Your Ref: OWPC15297
Our Ref: AB/103/17/PL 25-07-2017
Please ask for:
Mrs A Gardner

Change of use from veterinary office & treatment room (D1 Non Residential Institutions) to 1 No. additional dwellings with alterations to external fenestration. This application is a Departure from the Development Plan (amendment to AB/82/16/PL).

Former Reception Building Arundel Equine Hospital Tortington Lane Arundel

client:
Clarendon Properties Ltd
drawing title:
PLOTS 3&4 – Elevations

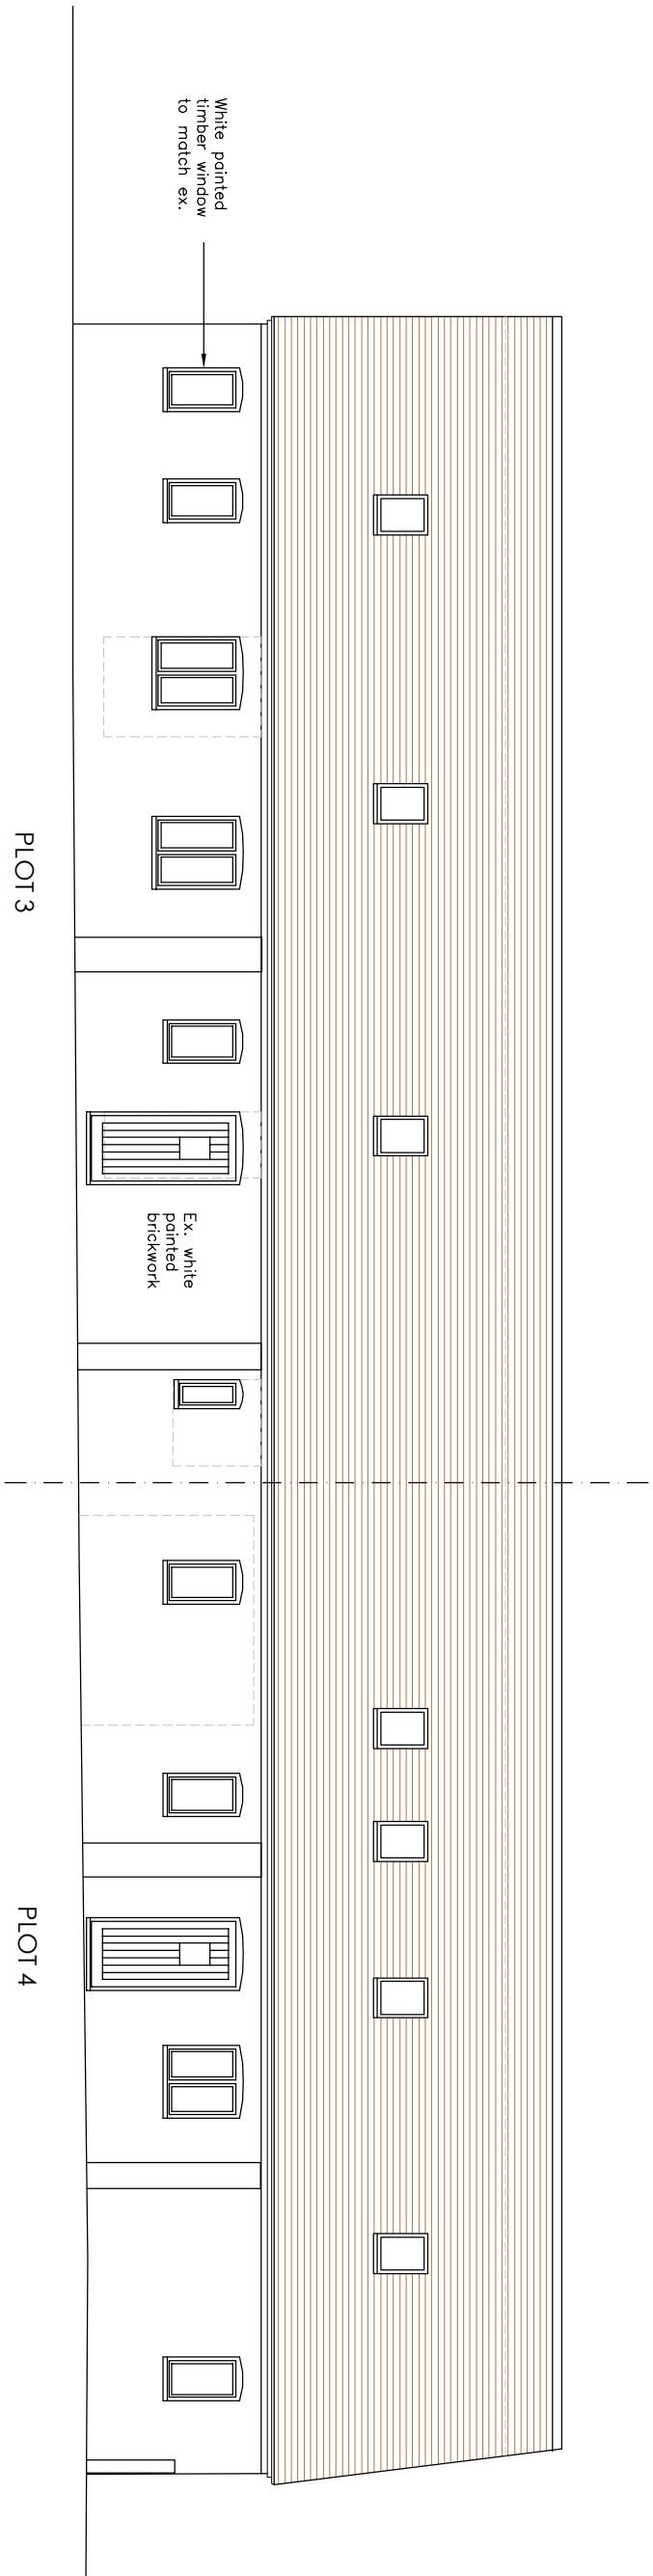
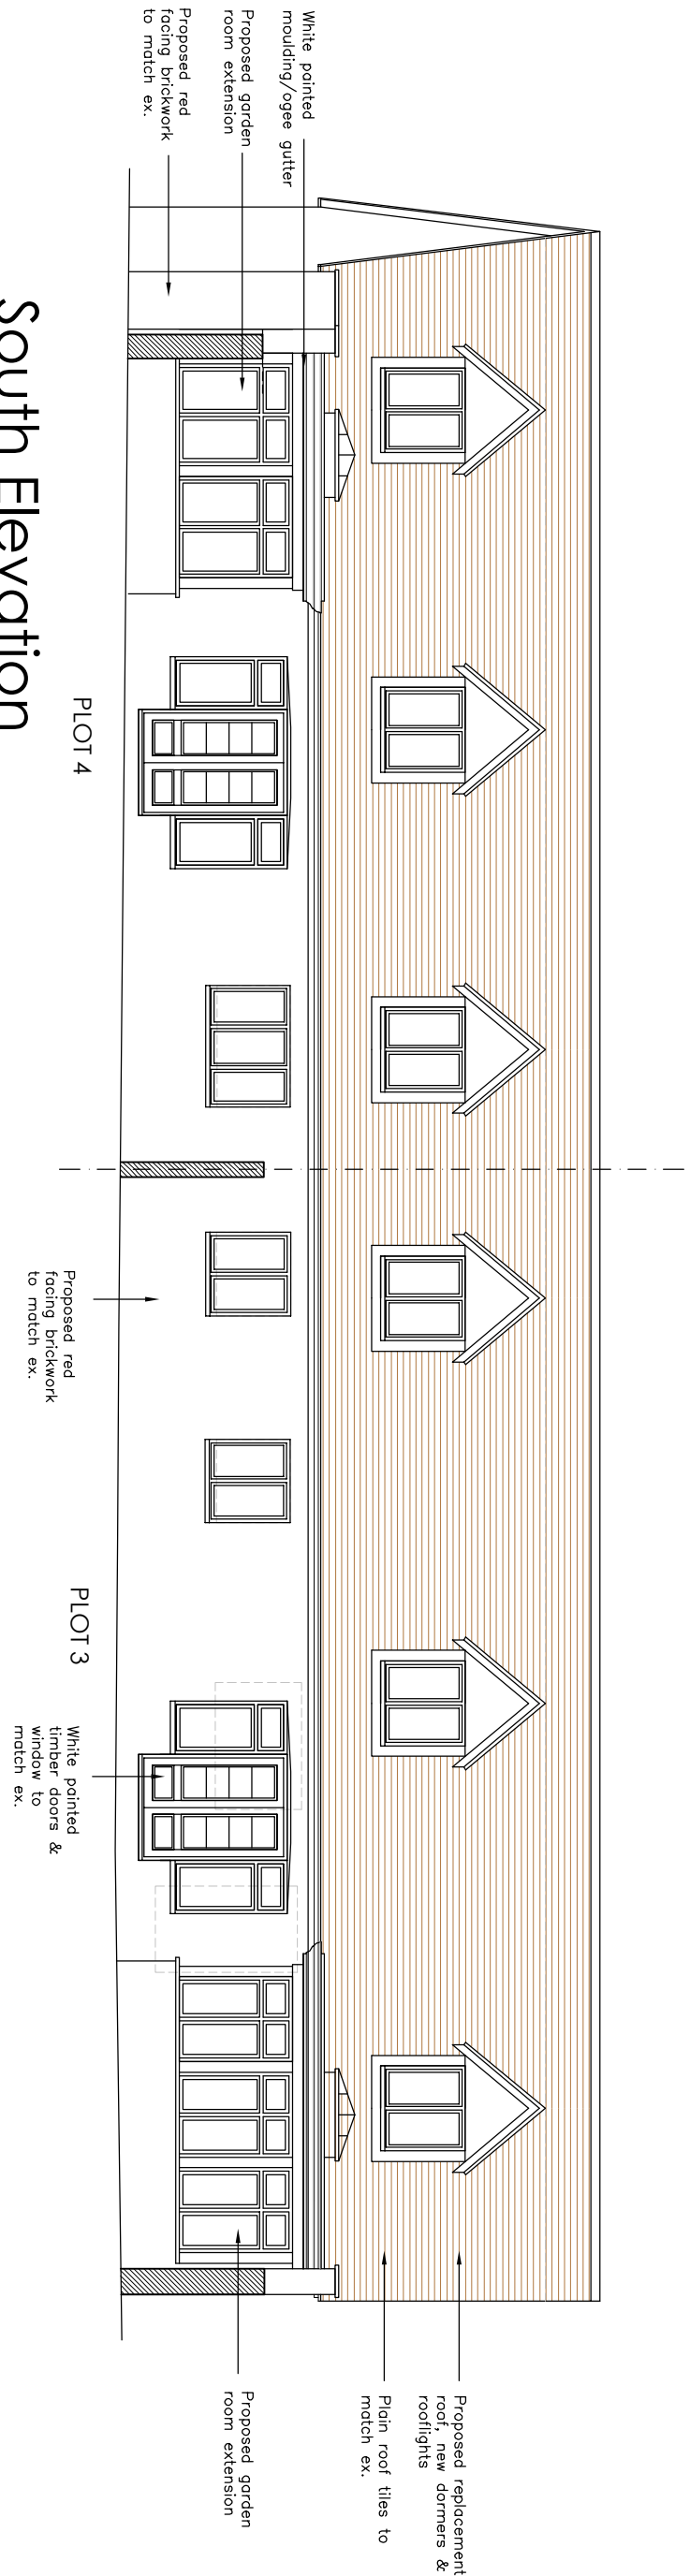
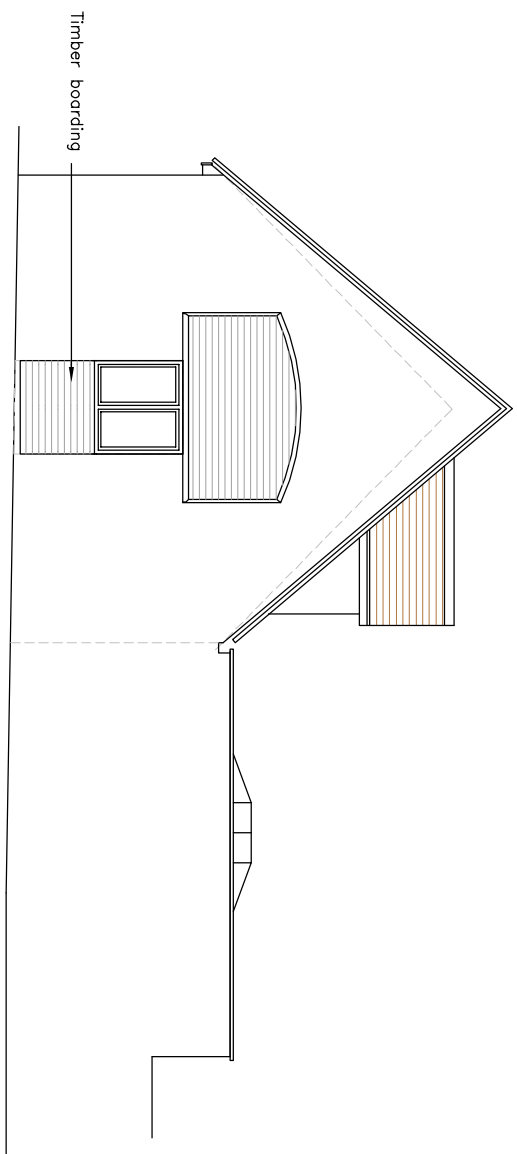
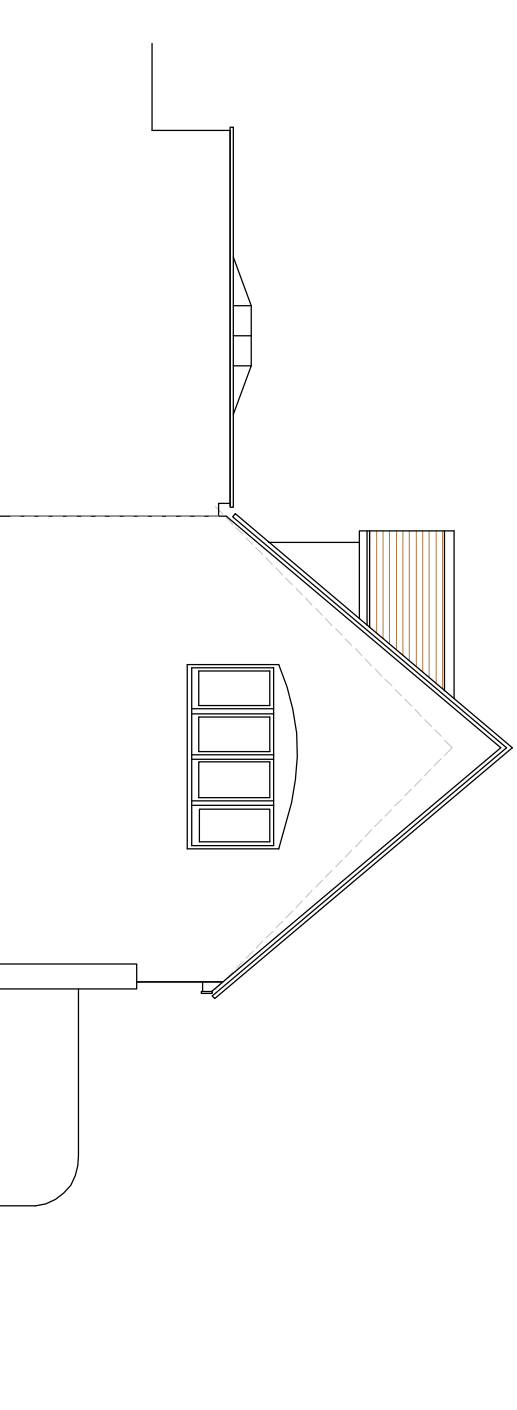
My home, Tortington House, borders the above application to the South elevation of the former reception building. My concern would be any loss of privacy due to any high level roof dormer or window that might overlook the existing neighbouring property. It appears that this concern has been addressed with the re-submission of the alternative layout which indicates the dormers are positioned on the North roof elevation. With this being the case I fully support this application and feel such a development will improve the character of the area and the use as a dwelling is likely to have less impact upon the residential amenities of neighbouring properties than that of an alternative business or commercial use.
